Subject: RE: Planning Consultation on: BR/139/20/PL

Application No: BR/139/20/PL

Site Address: 29 Highcroft Crescent Bognor Regis PO22 8DH

Description of Works: Re-establishment of dwelling to form former pair of semi-detached bungalows.

Proposed

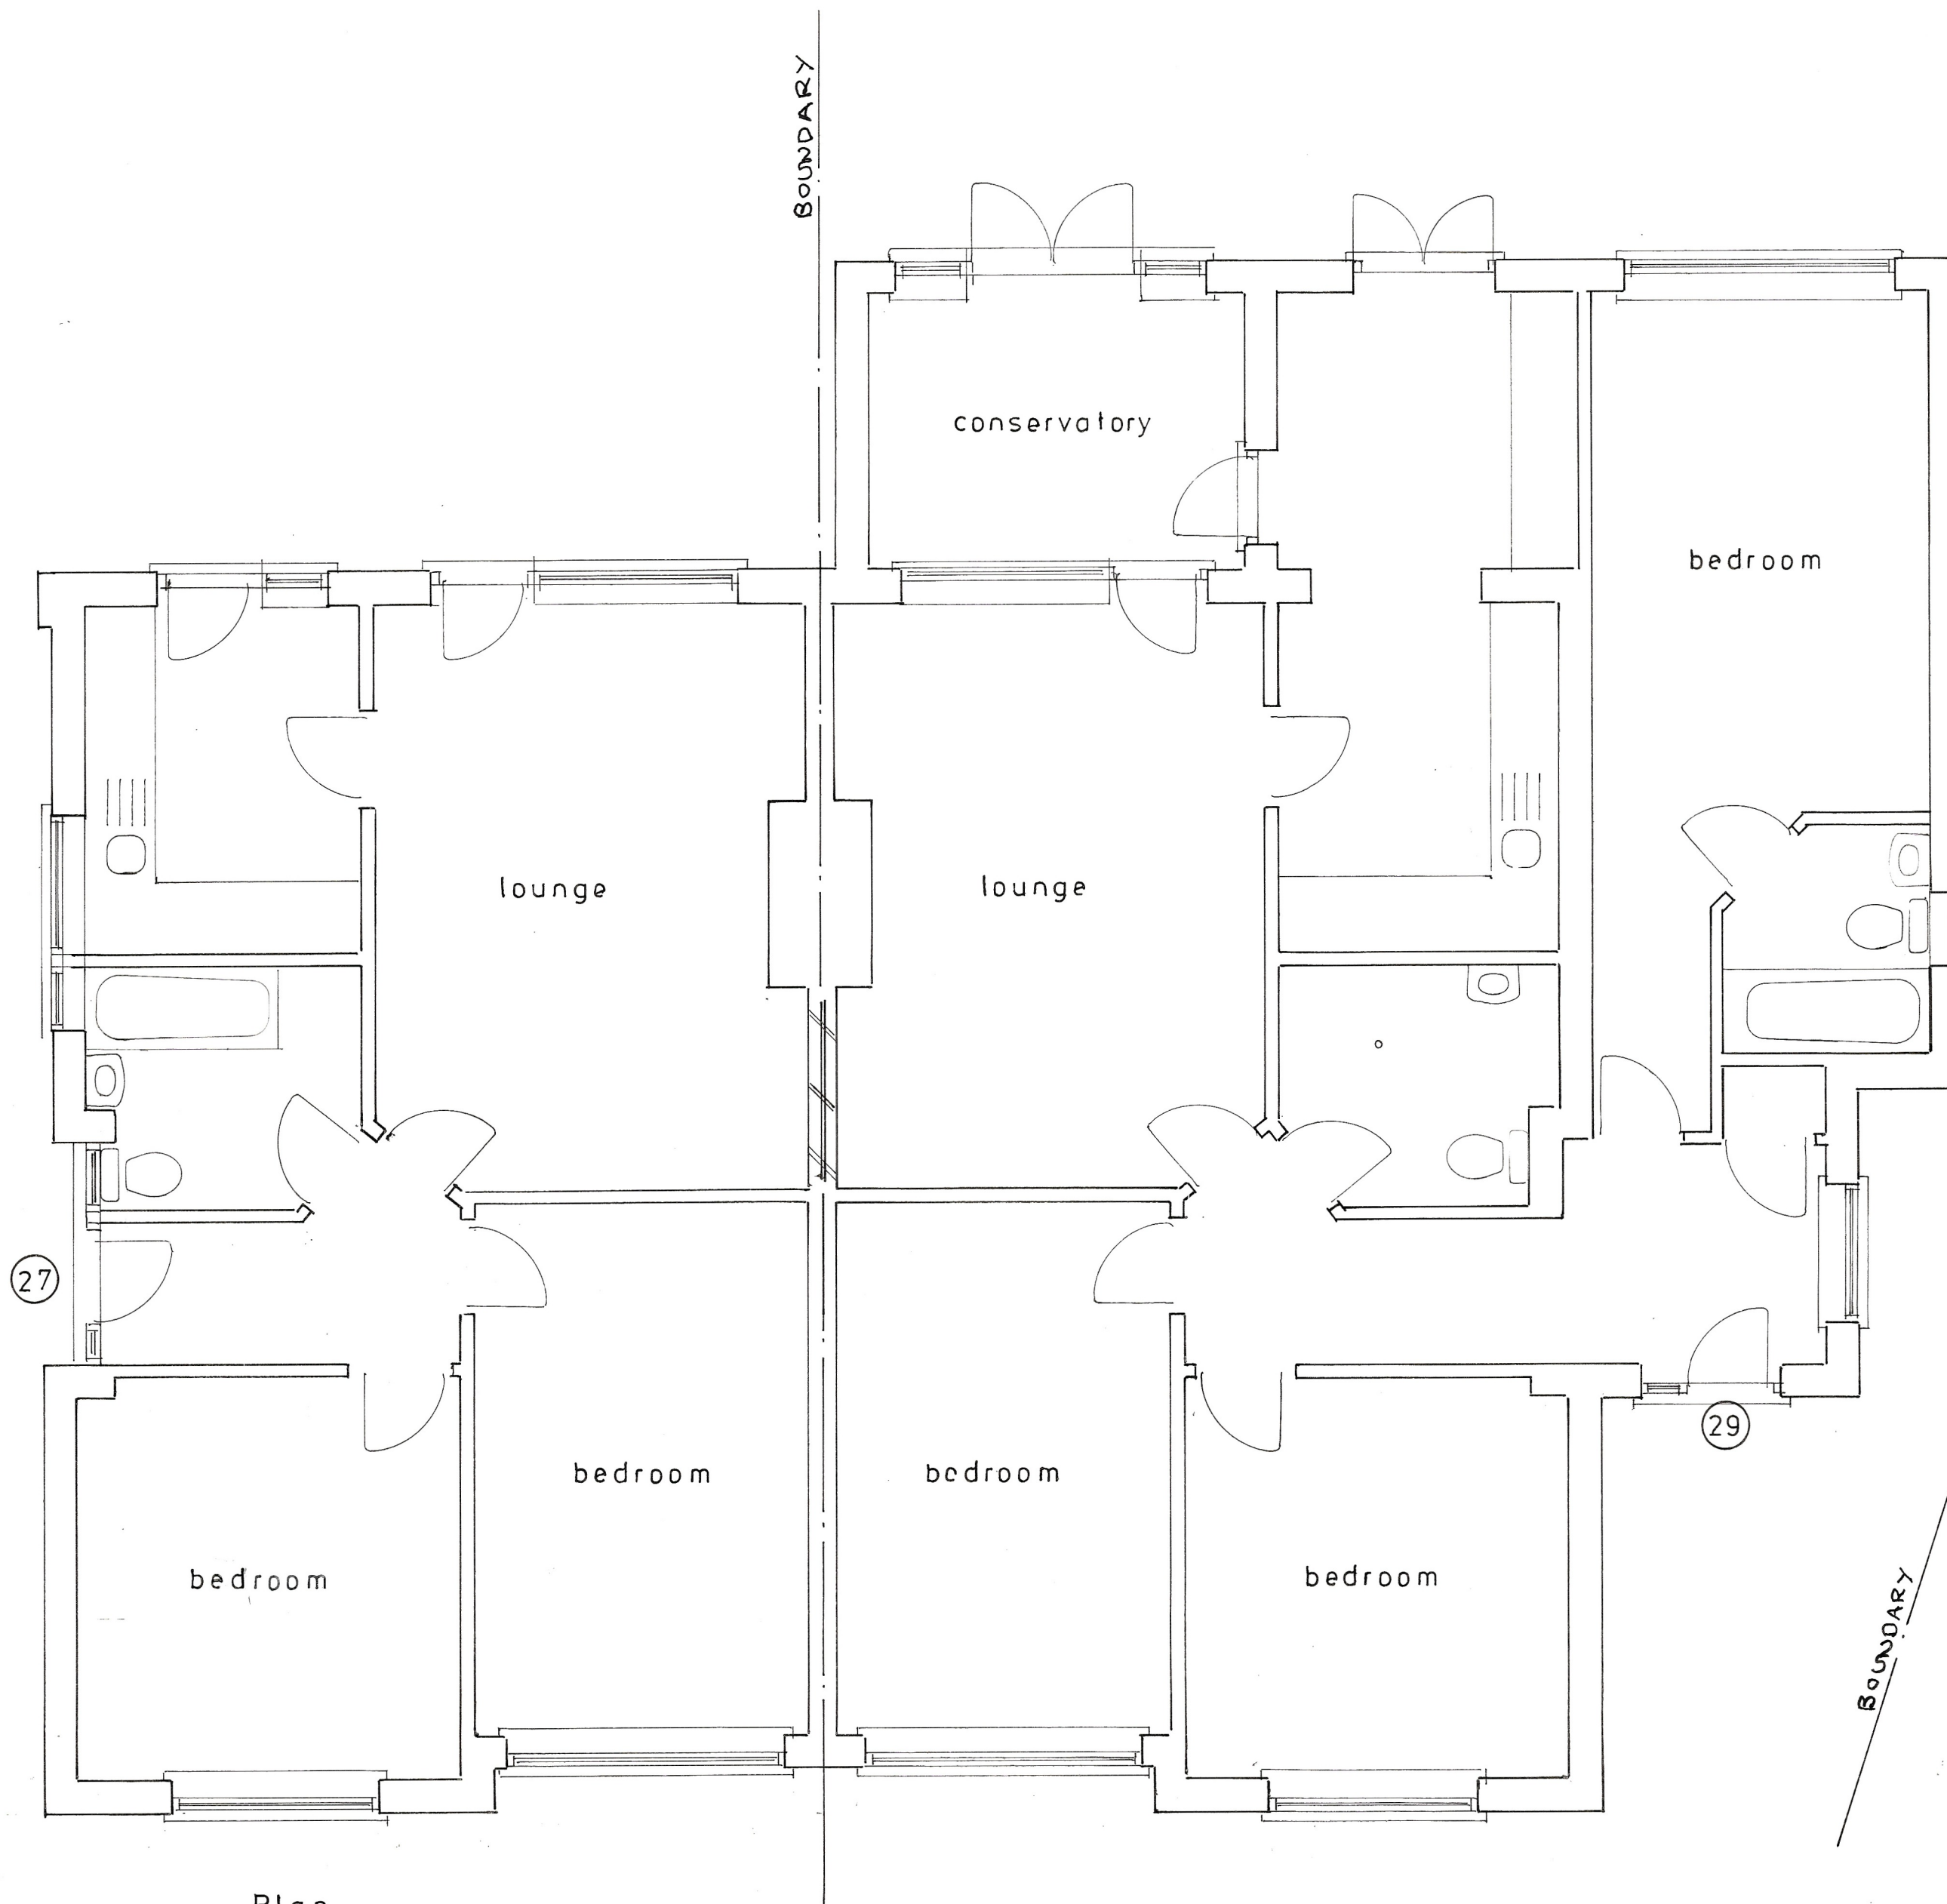
- There does not appear to be a bath or shower present within the shared bathroom in number 29; it appears there is only a bath present within the en-suite bathroom contained within one of the bedrooms. It is likely this has just not been included within the plan, but for clarification, a bath/shower should be provided to the shared bathroom
